Notice of Proposed Modification Application MP 08_0238 MODs 6 & 7 (North Sydney LGA)

Thank you for your email message dated 16 November 2016, requesting Transport for NSW (TfNSW) review and comment on the above modification proposal.

Figure 2: Proposed Laneway Strategy

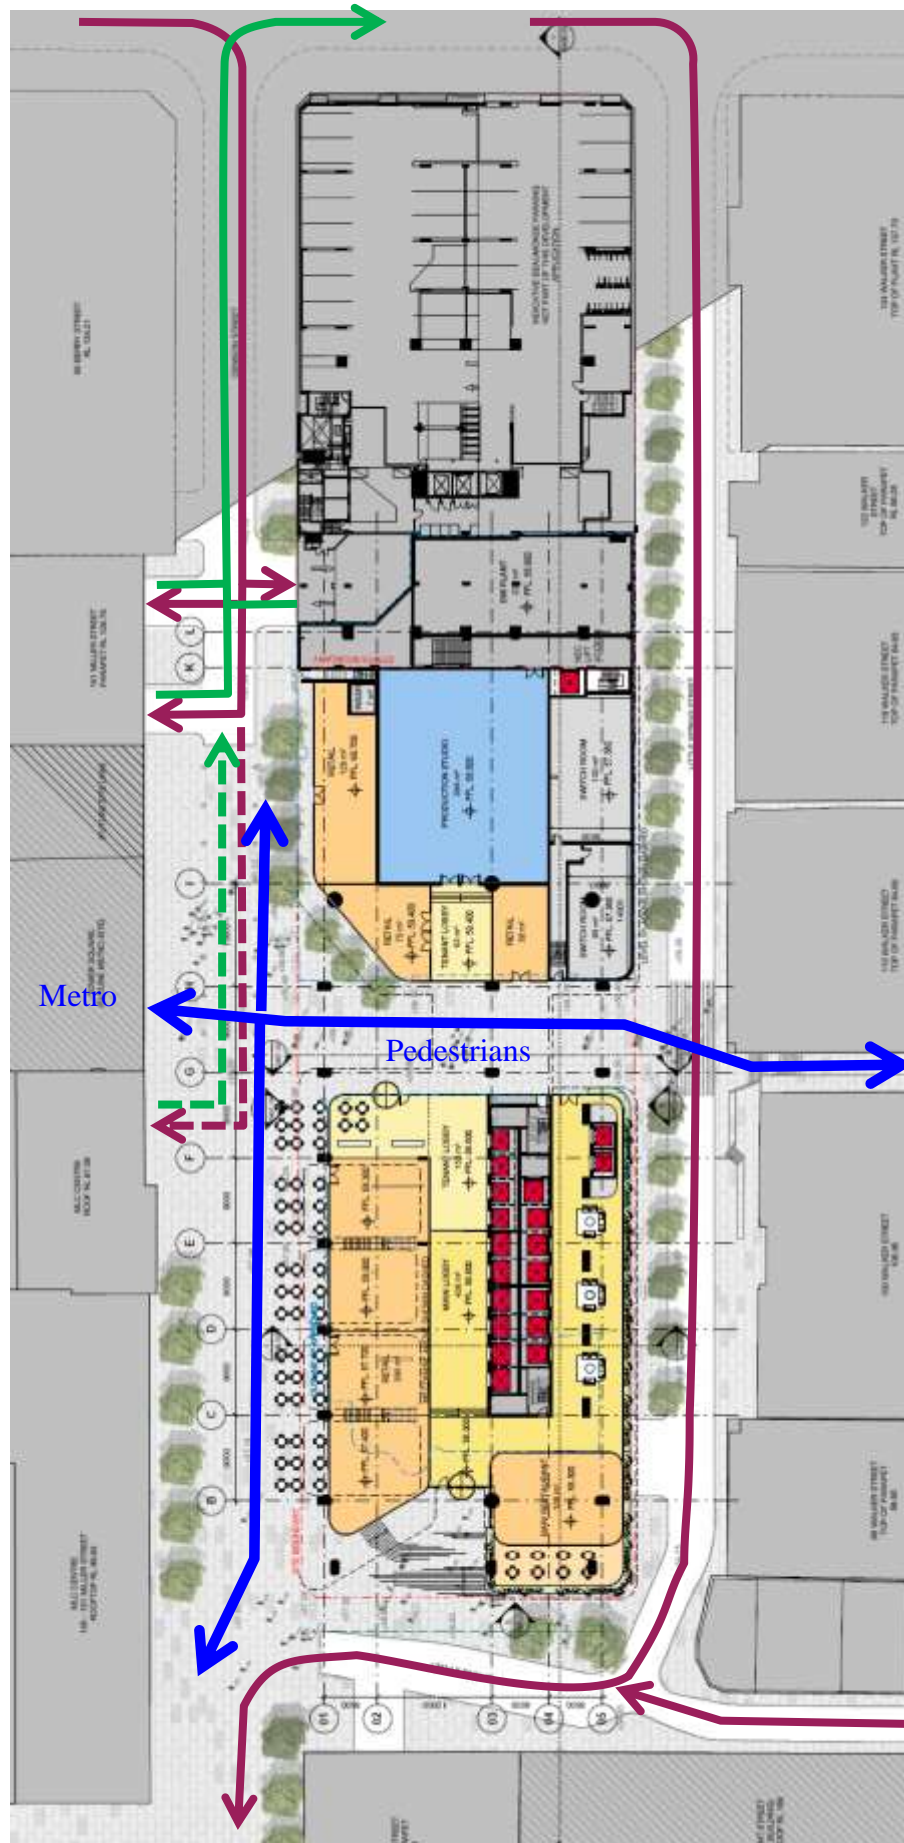
It is noted that road network changes are proposed as part of the modification proposal. It is requested that the applicant be conditioned to:

- Consult with TfNSW and Roads and Maritime Services prior to the finalisation of the plans for the proposed road network changes; and
- Obtain approval from Roads and Maritime Services for the proposed shared zone arrangement along Denison Street.

- Consult with TfNSW and Roads and Maritime Services prior to the finalisation of the plans for the proposed road network changes; and
- Obtain approval from Roads and Maritime Services for the proposed shared zone arrangement along Denison Street.
